Ref 2450.corr.RVBC250807

Barn at Lower Reaps Farm, Whinney Lane, Mellor, BB2 7EL

Application references 3/2025/0507 and 0508

project	project number	drawing number
<b>lower reaps farm - barn</b>	<b>24.50</b>	<b>pl.11</b>
name		
<b>proposed - plans</b>		
scale	date	status
1 to 100 @ A1	may 24	planning
revision		D

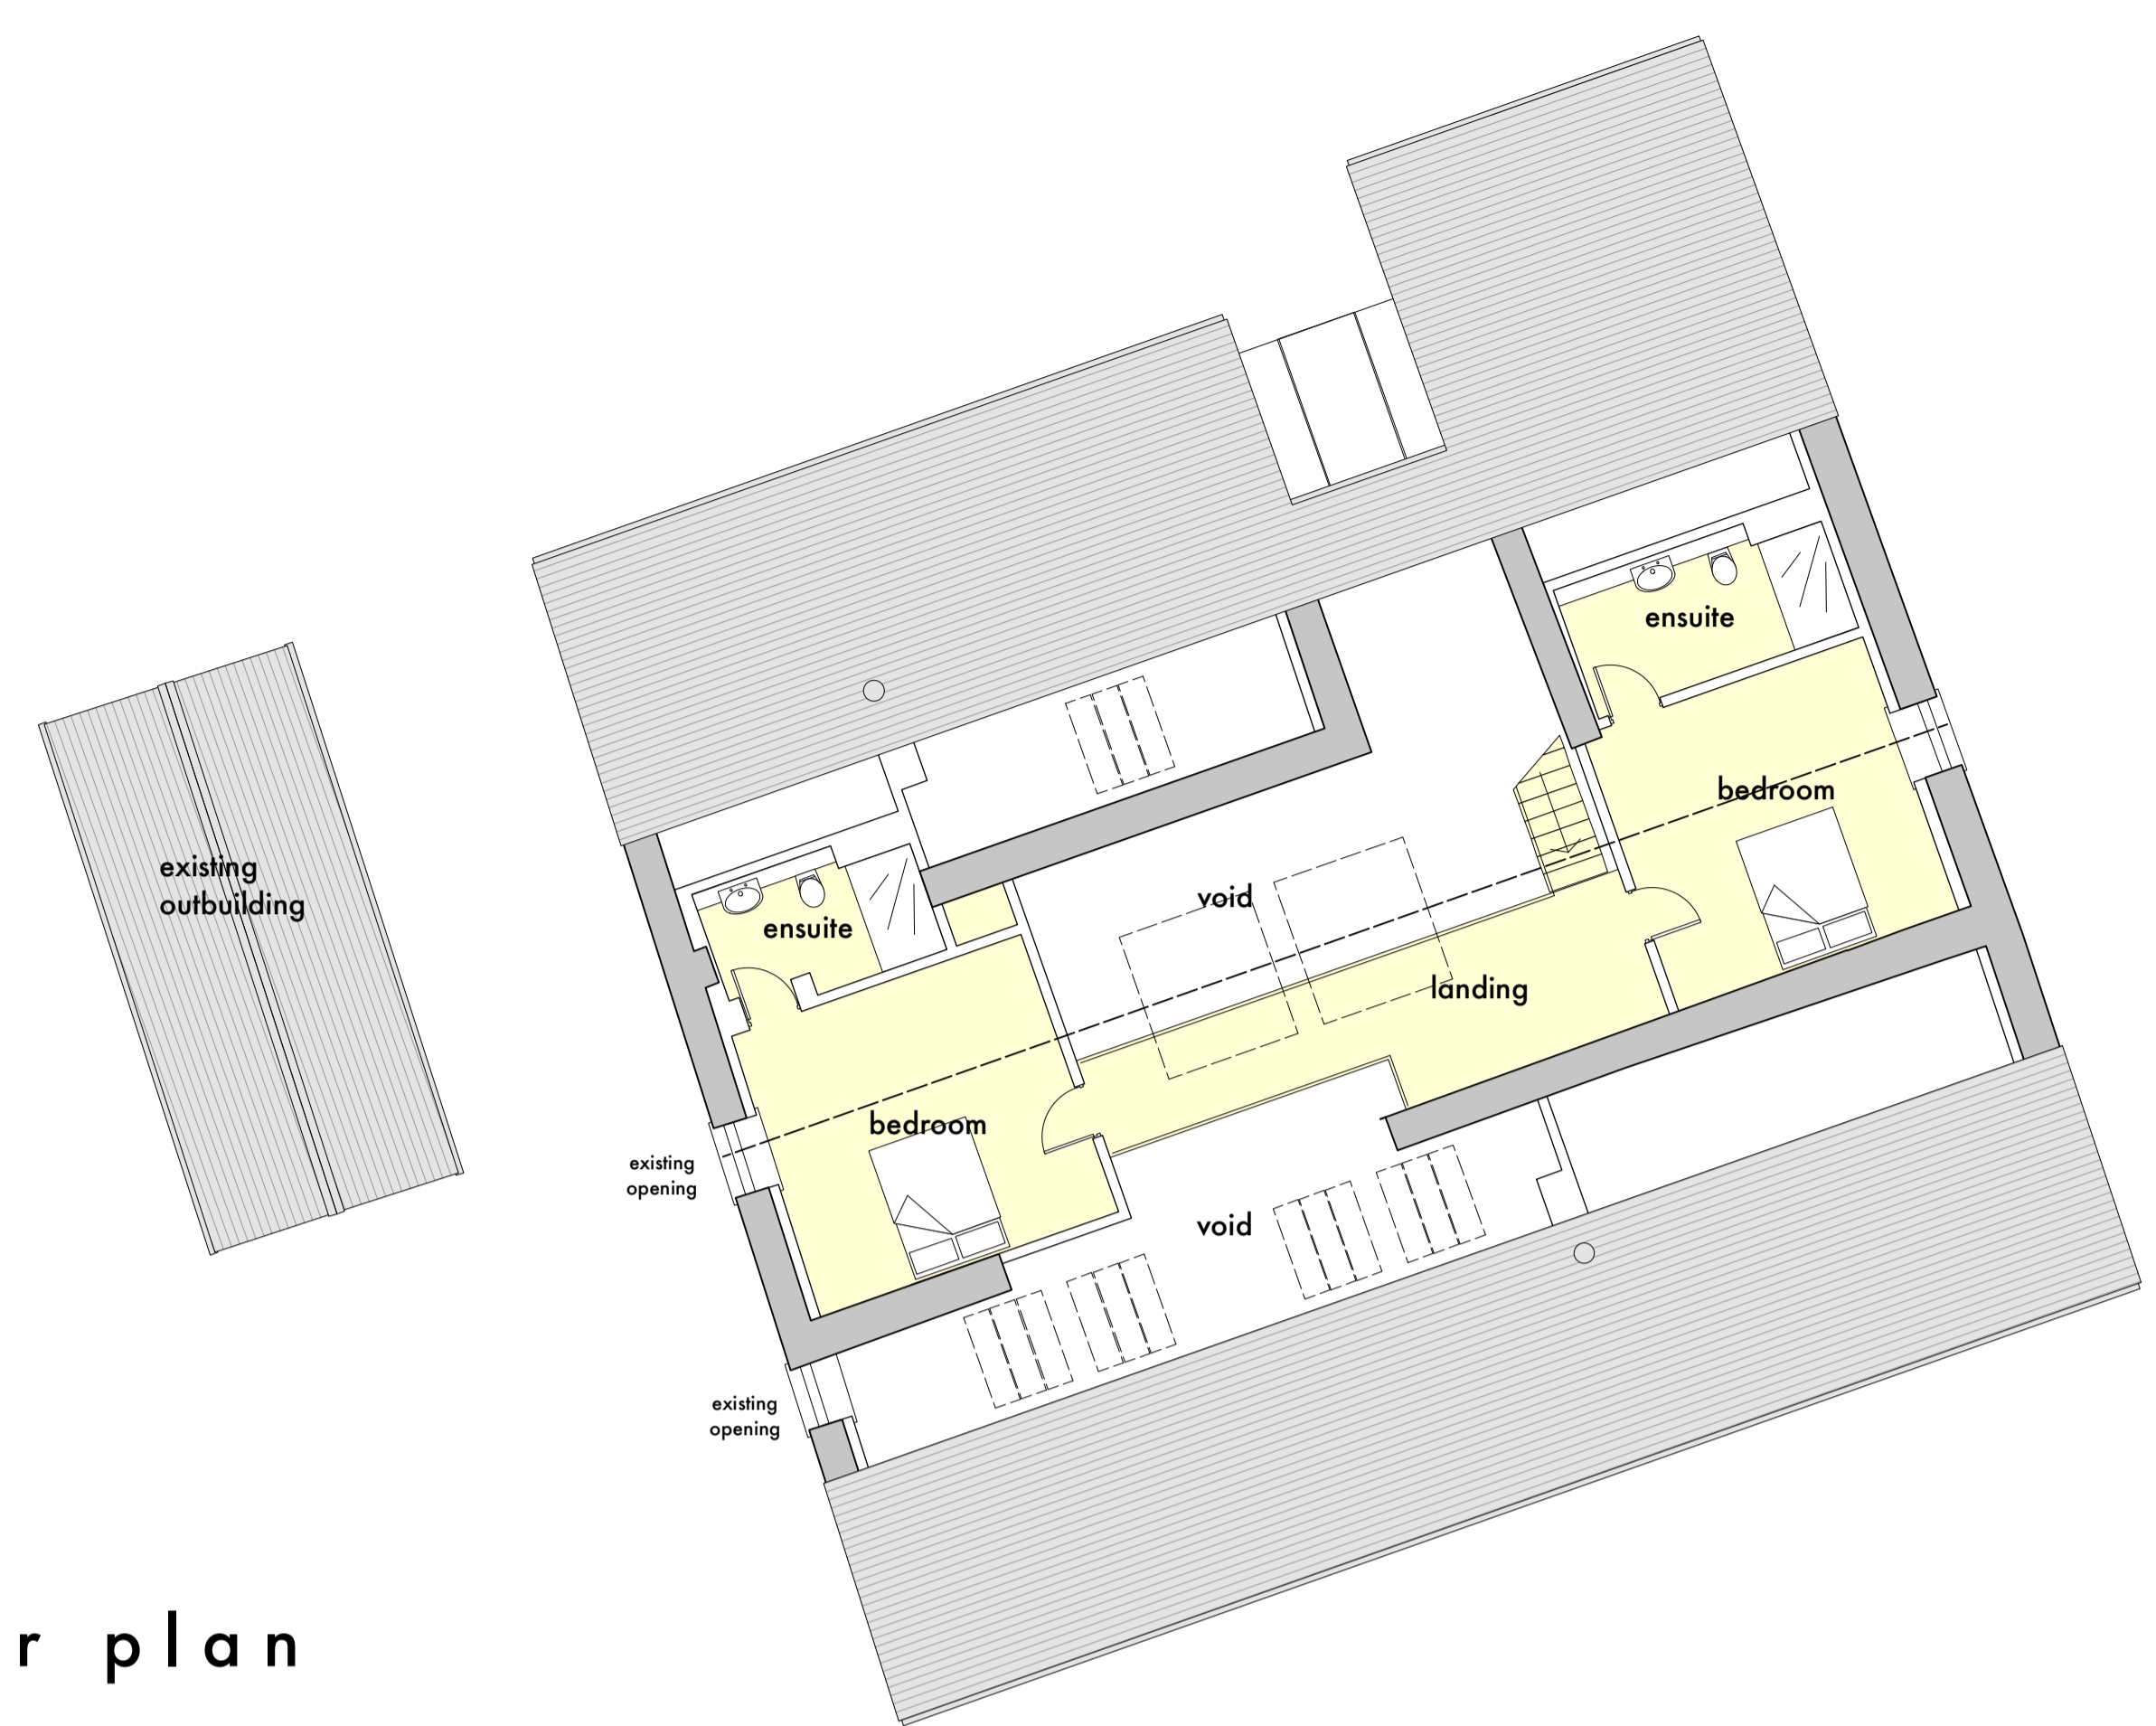
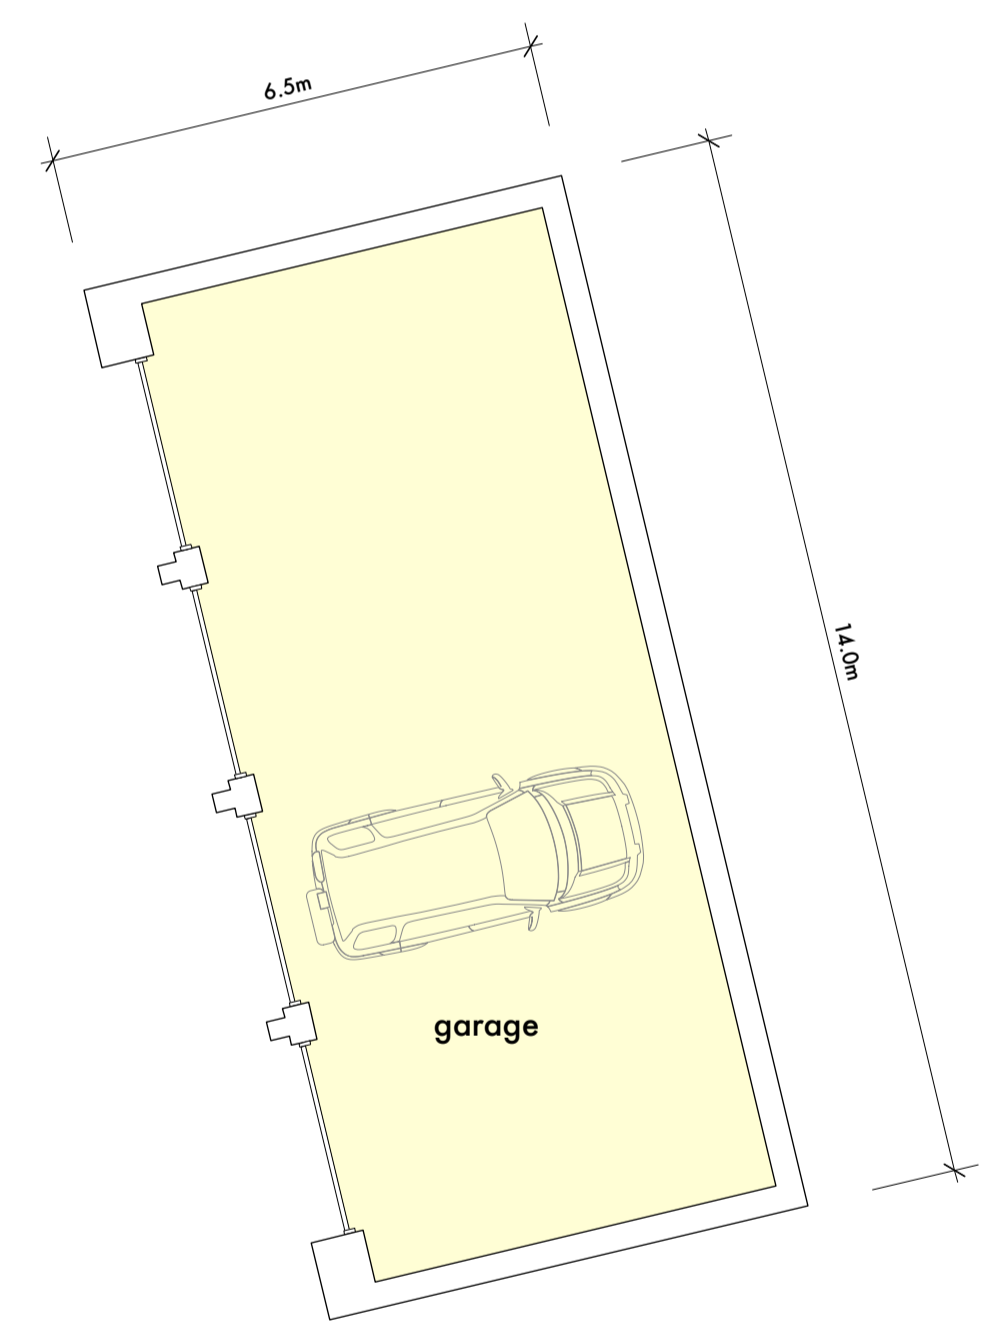
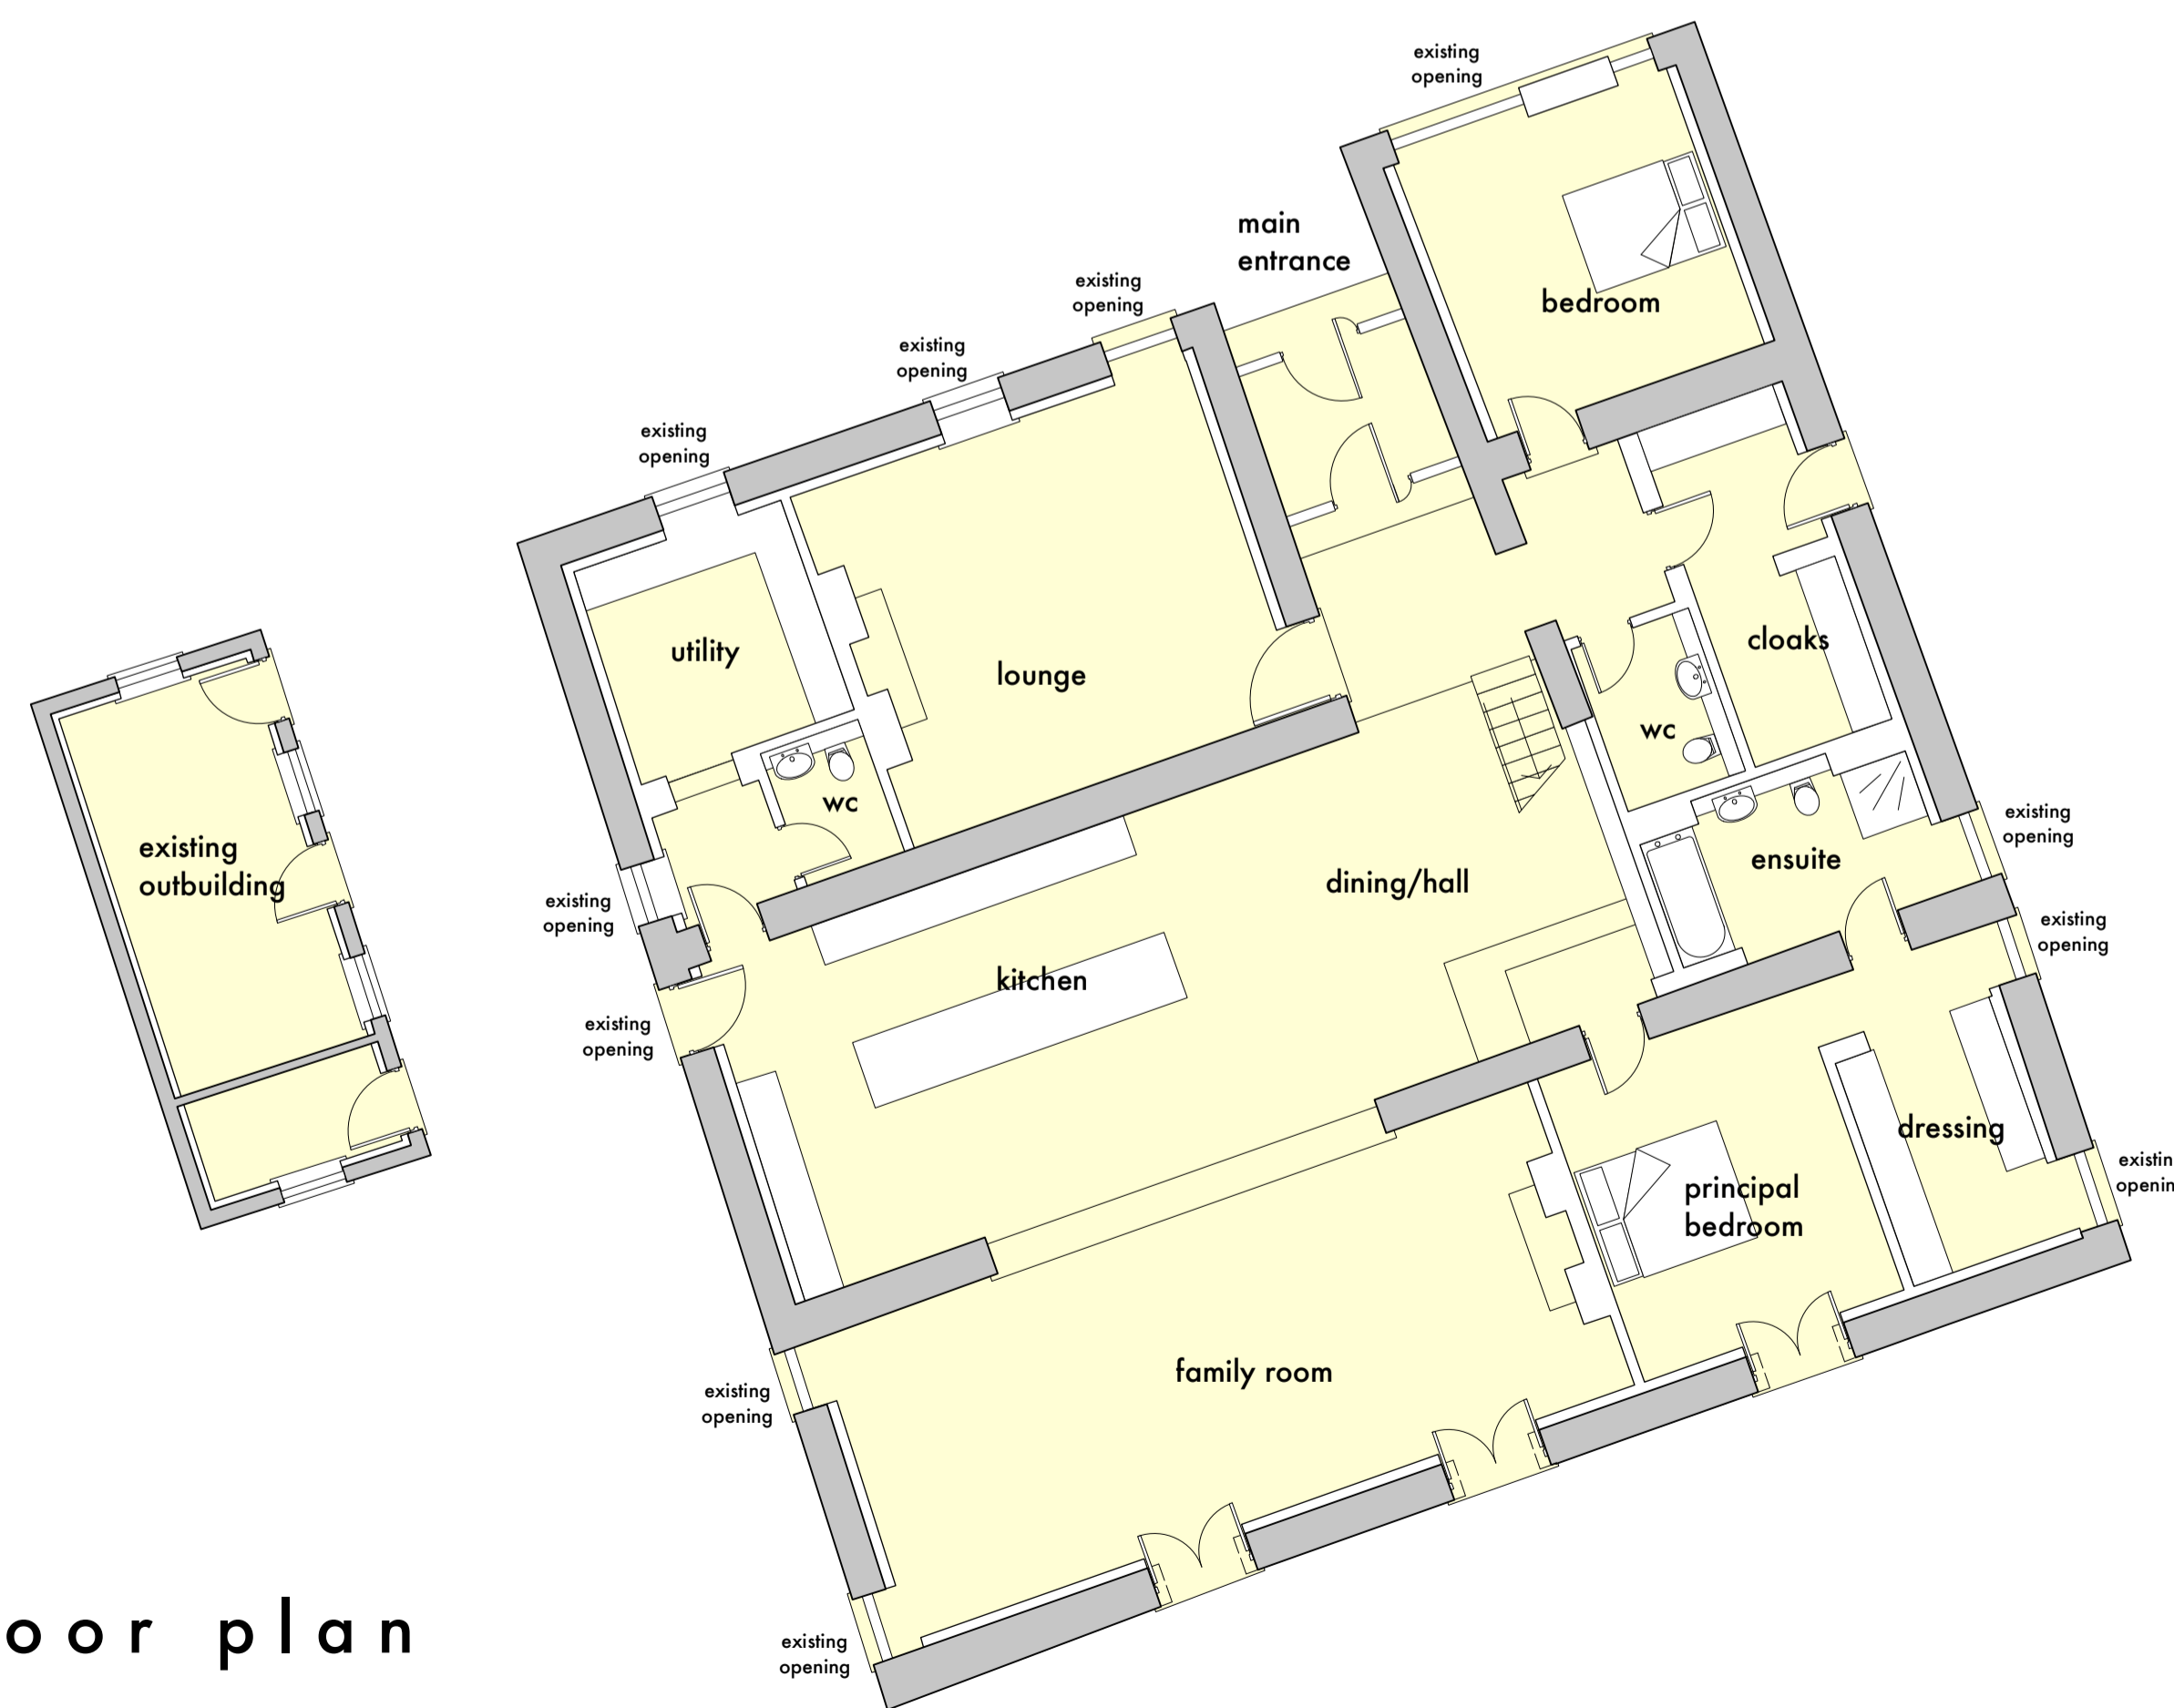
The CBA comment on proposed south facing openings and state the opinion that they 'erode the agricultural character of the building'. Following discussion with our client, the decision has been taken to further reduce the width of the proposed openings to now match the width of the existing openings to the neighbouring outbuilding. Dressed stone surrounds to the openings will be detailed to match the existing surrounds to door openings to the barn. The proposed openings will be fitted with 'French' style doors and not 'bifold' doors as suggested in the CBA correspondence. The proposed doors will be in keeping with the barn and setting whilst allowing access from the family room and principal bedroom to the garden. The reduced width will also help address the 'glare' suggested in the CBA correspondence.

Drg.no.2450/11 revision B

proposed - plans
